Our Reference: **SHARE/ 76010428**
Your Reference: West Midlands Interchange

WEST MIDLANDS INTERCHANGE DCO - DEADLINE NO. 8 SUBMISSION

This is Highways England's Deadline 8 submission. It confirms matters that remain outstanding between the applicant and ourselves.

## **Transport Technical Note 46 – A449 / A5 Link Road Signalised Crossing**

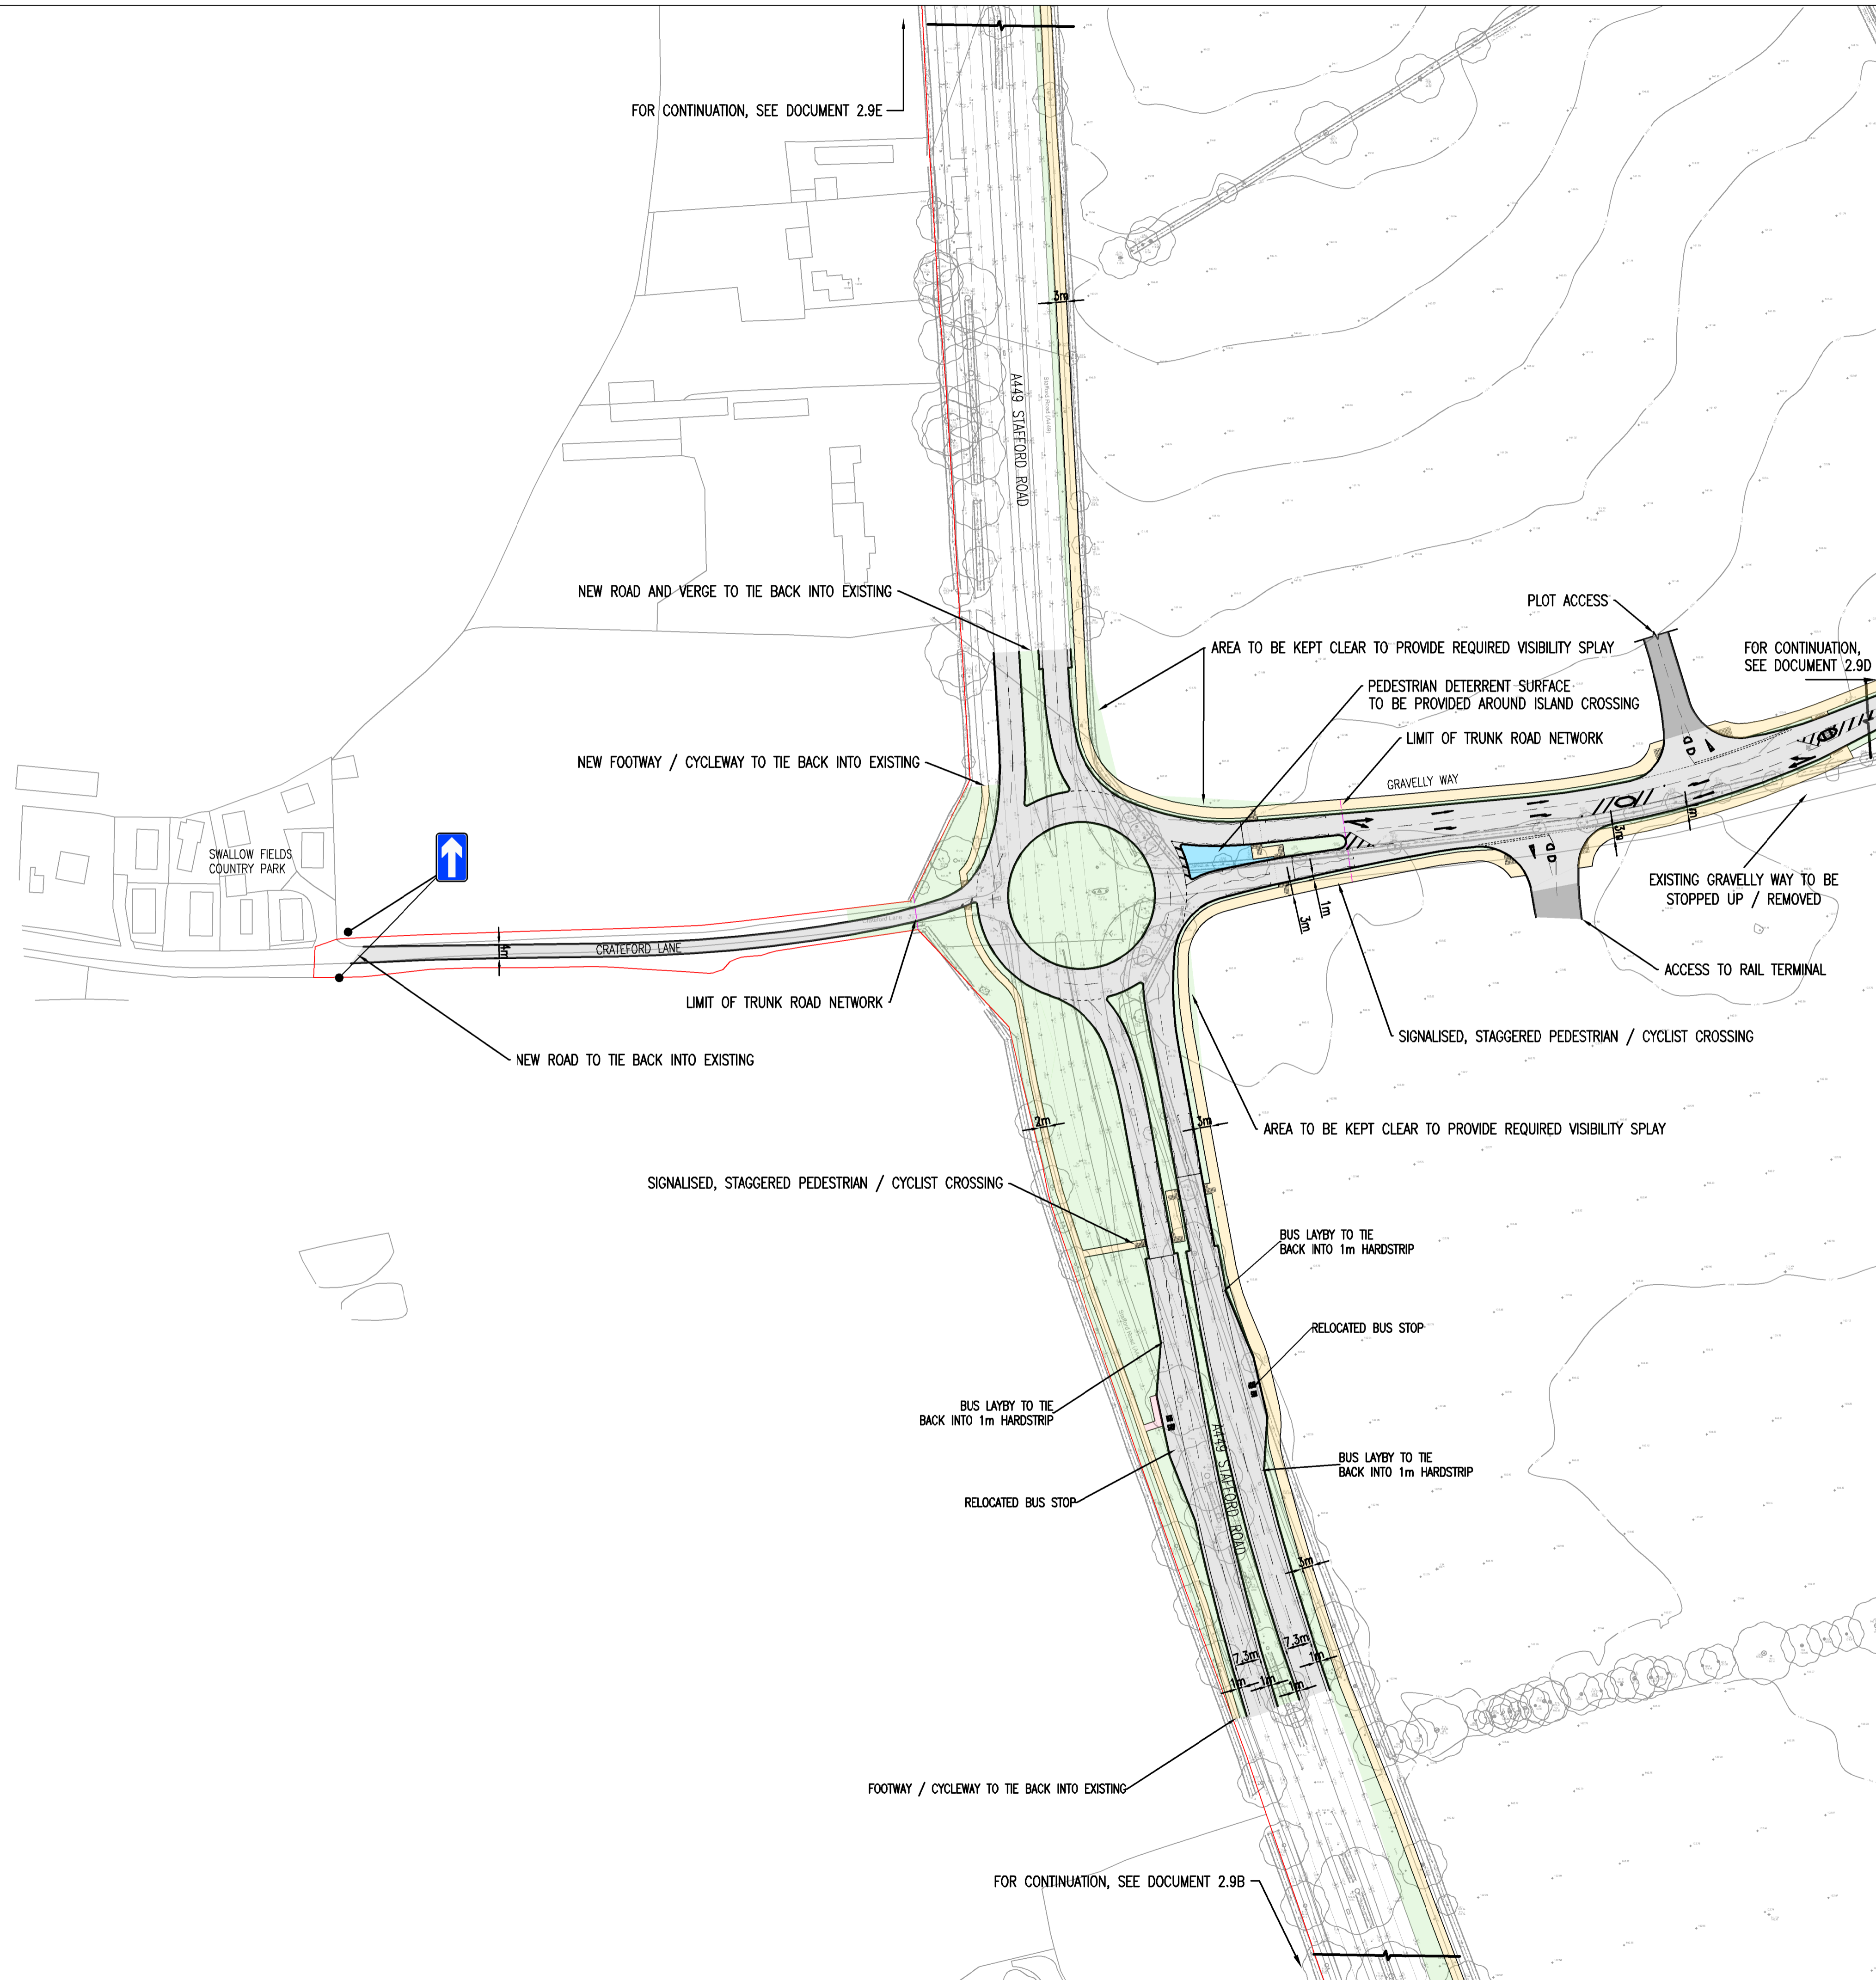
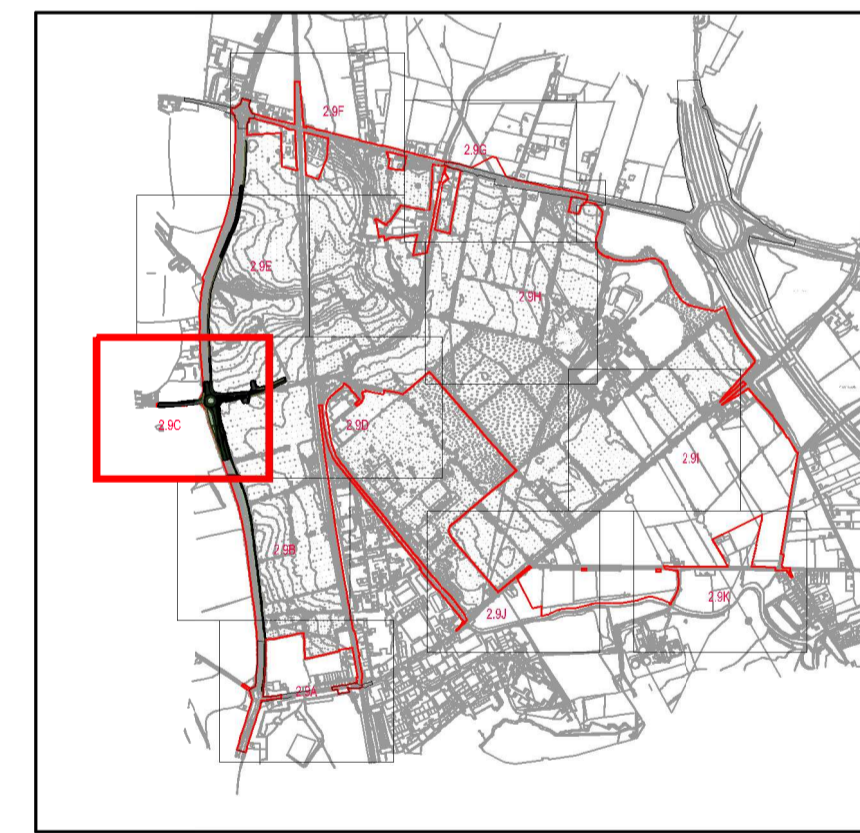
The location of the proposed pedestrian crossing of the A449/A5 link road adjacent to the A449 access roundabout has been moved in response to the RSA Stage 1 findings. The

audit process and consideration of the need for a GG104 safety risk assessment² has not been concluded at the newly proposed location. An early iteration of the Safety Risk Assessment submitted by the applicant on 2nd August 2019 has not followed the correct procedure and the outcomes quoted cannot therefore be relied upon. We do note, however, that the designer now intends to produce a DMRB compliant design (noting the need for compliance with the new standard CD 116 which has superseded TD 16/07) which should, subject the completion of the RSA process negate the need for a Road Safety Audit exception report for this element of the highway design being required. However the applicant's traffic modelling of the pedestrian crossing indicates that traffic will block back from the crossing onto the proposed A449/link road roundabout. This is as a result of the crossing being relocated closer to the roundabout; this is a safety concern which will require resolution through the further stages of the audit process.
